Pear tree Hill Solar Farm

Environmental Statement Addendum

Application Document Ref: EN010157/APP/8.2

October 2025

Figure 7.1: Designated Sites and Ecological Mitigation and Enhancement Areas

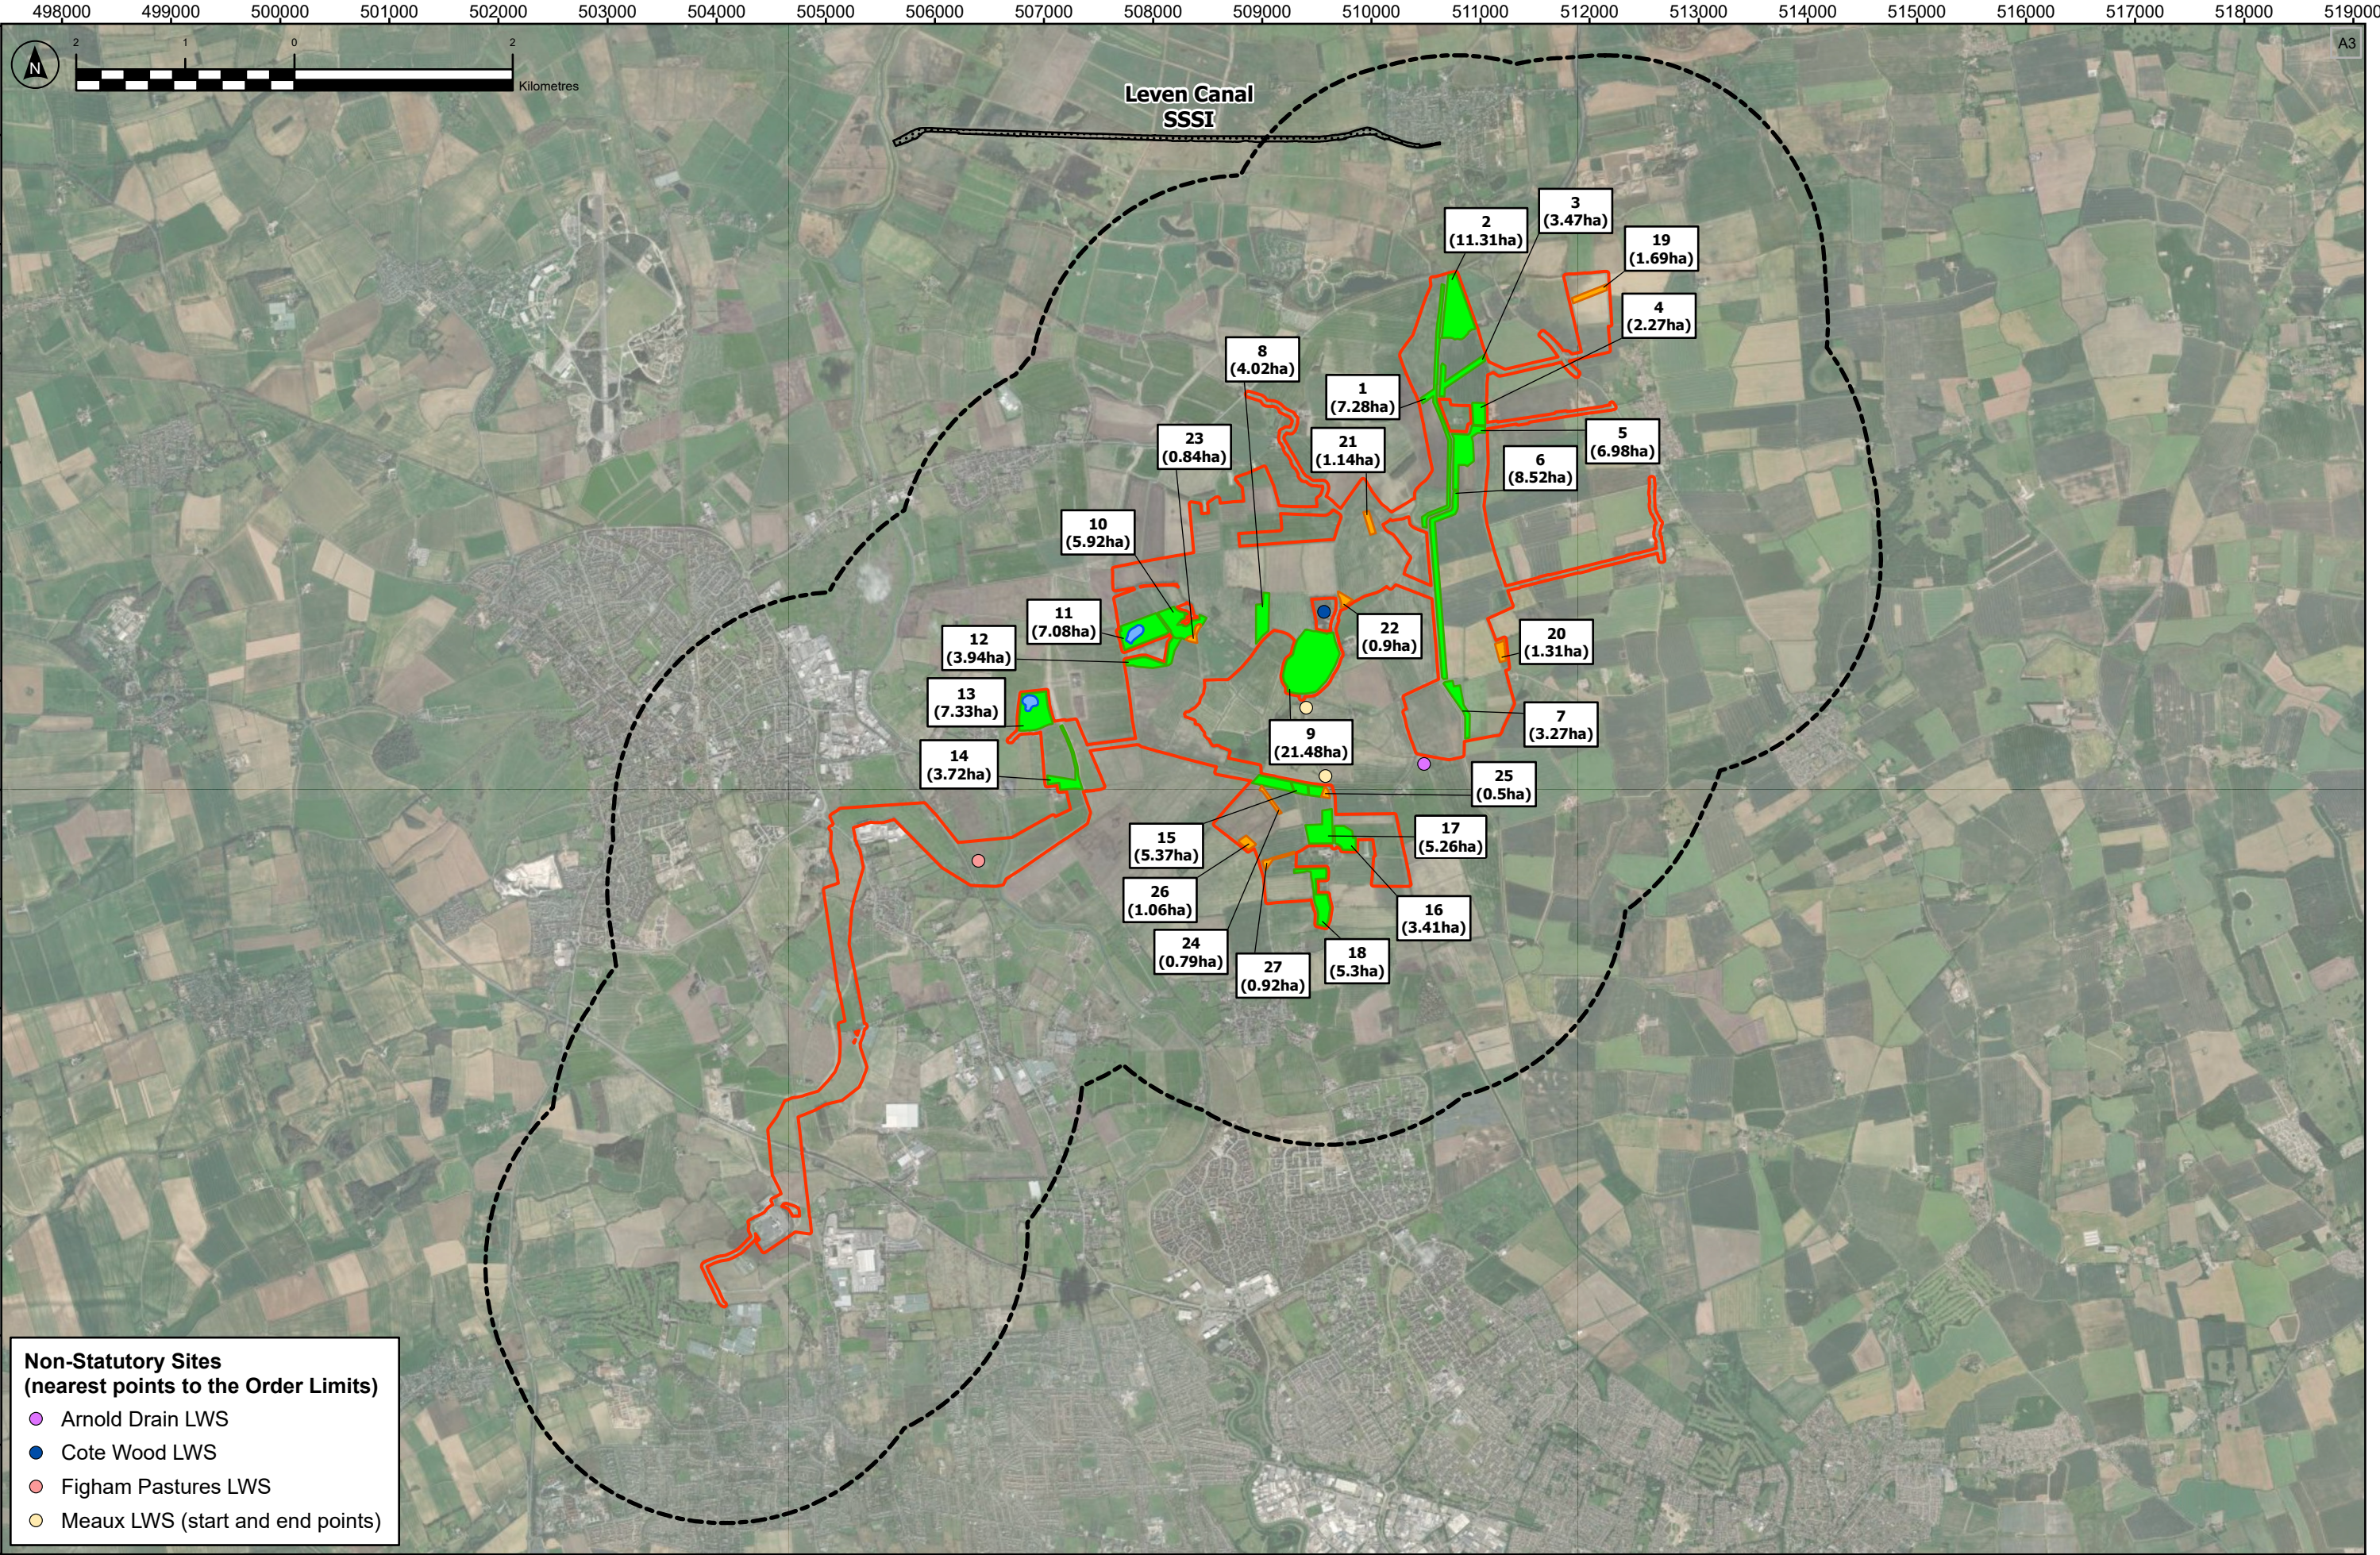
ES Volume 3, Figure 7.1: Designated Sites and Ecological Mitigation and Enhancement Areas [APP-065]	Figure 7.1 requires amendment to reflect the removal of plots 10-4, 10-5 and 10-6 as part of change/correction 2.	
ES Volume 3, Figure 7.2: Biodiversity Study Areas [APP-066]	Figure 7.2 requires amendment to reflect the removal of plots 10-4, 10-5 and 10-6 as part of change/correction 2.	
ES Volume 3, Figure 9.1: Cultural Heritage Study Areas [APP-067]	Figure 9.1 requires amendment to reflect the removal of plots 10-4, 10-5 and 10-6 as part of change/correction 2.

Figure 9.2: Assessed Designated Heritage Assets

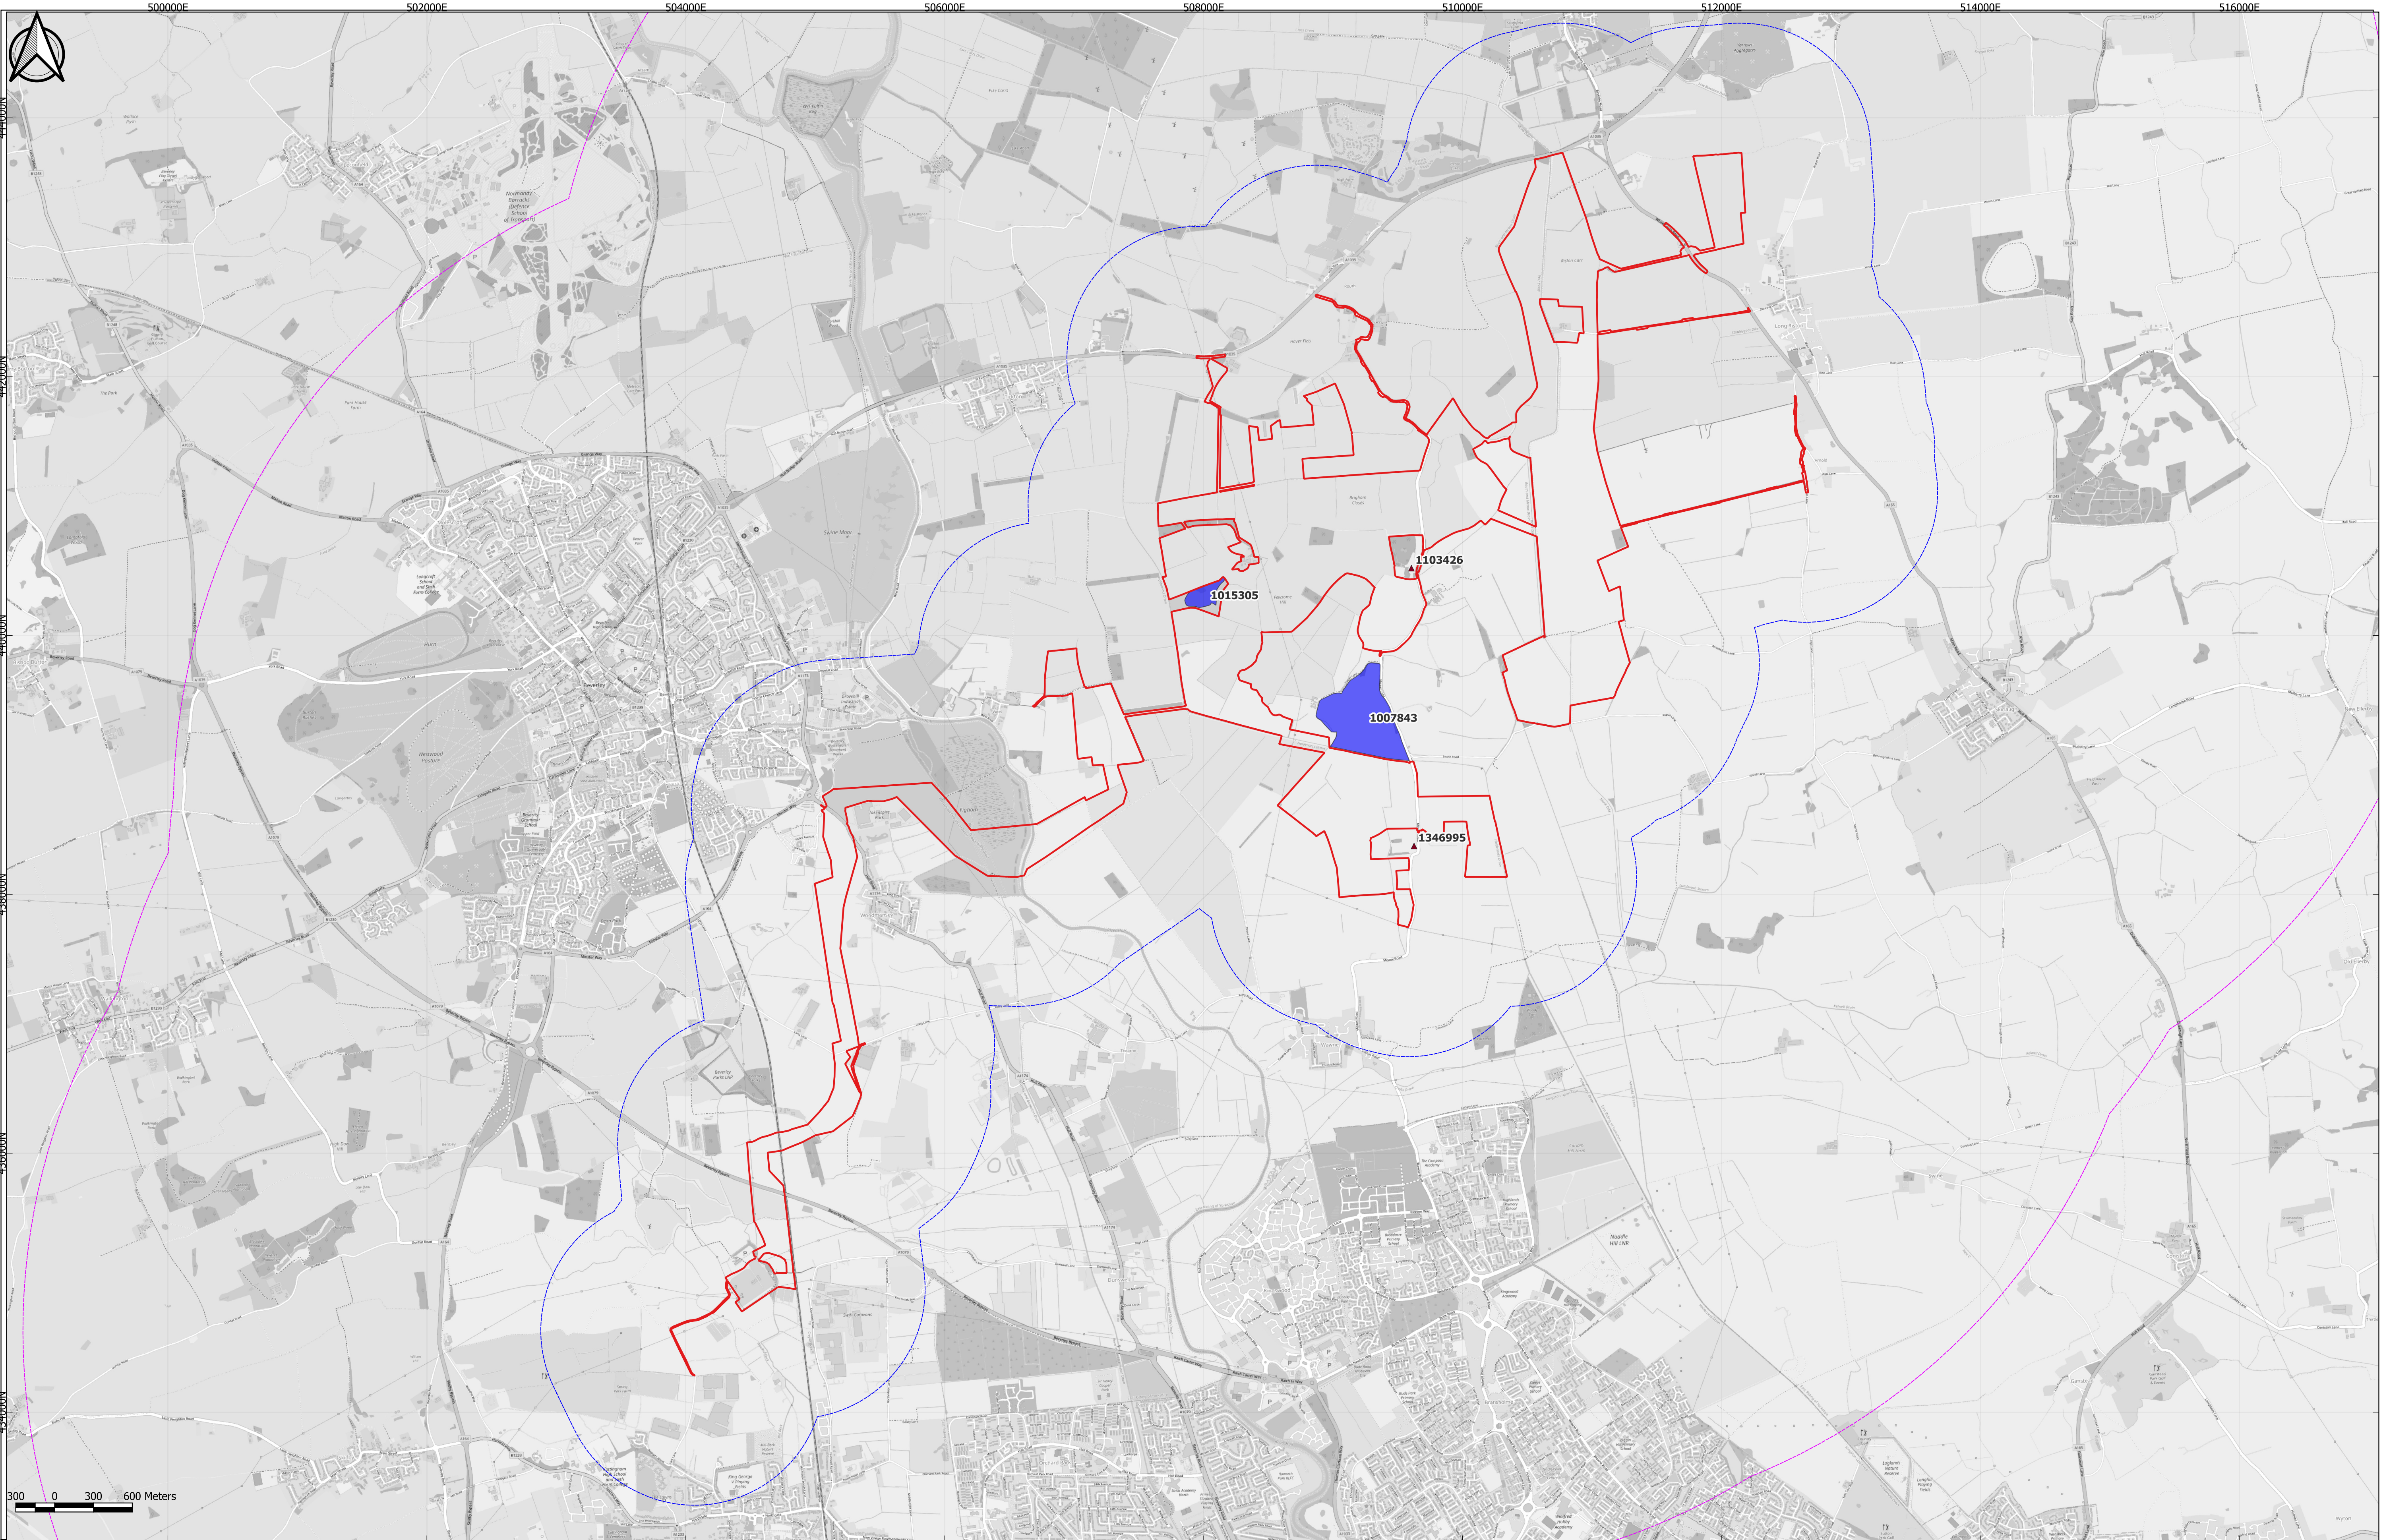
Document reference	Reason for amendment	ES Amendment July 2025
ES Volume 3, Figure 9.2: Assessed Designated Heritage Assets [APP-068]	Figure 9.2 requires amendment to reflect the removal of plots 10-4, 10-5 and 10-6 as part of change/correction 2.	
ES Volume 3, Figure 9.3: Assessed Non-Designated Heritage Assets [APP-069]	Figure 9.3 requires amendment to reflect the removal of plots 10-4, 10-5 and 10-6 as part of change/correction 2.	
ES Volume 3, Figure 10.1: Study Areas and Key Features for Land, Soil and Groundwater [APP-070]	Figure 10.1 requires amendment to reflect the removal of plots 10-4, 10-5 and 10-6 as part of change/correction 2.	
ES Volume 3, Figure 10.2: ALC Blocks overlaid Land Areas [APP-071]	Figure 10.2 requires amendment to reflect the removal of plots 10-4, 10-5 and 10-6 as part of change/correction 2.	
ES Volume 3, Figure 11.1: Landscape Study Area, Context, Designations and Access [APP-072]	Figure 11.1 requires amendment to reflect the removal of plots 10-4, 10-5 and 10-6 as part of change/correction 2. Figure 11.1 also requires amendment to reflect the removal of a section of solar array from Land Area B as part of change/correction 1.
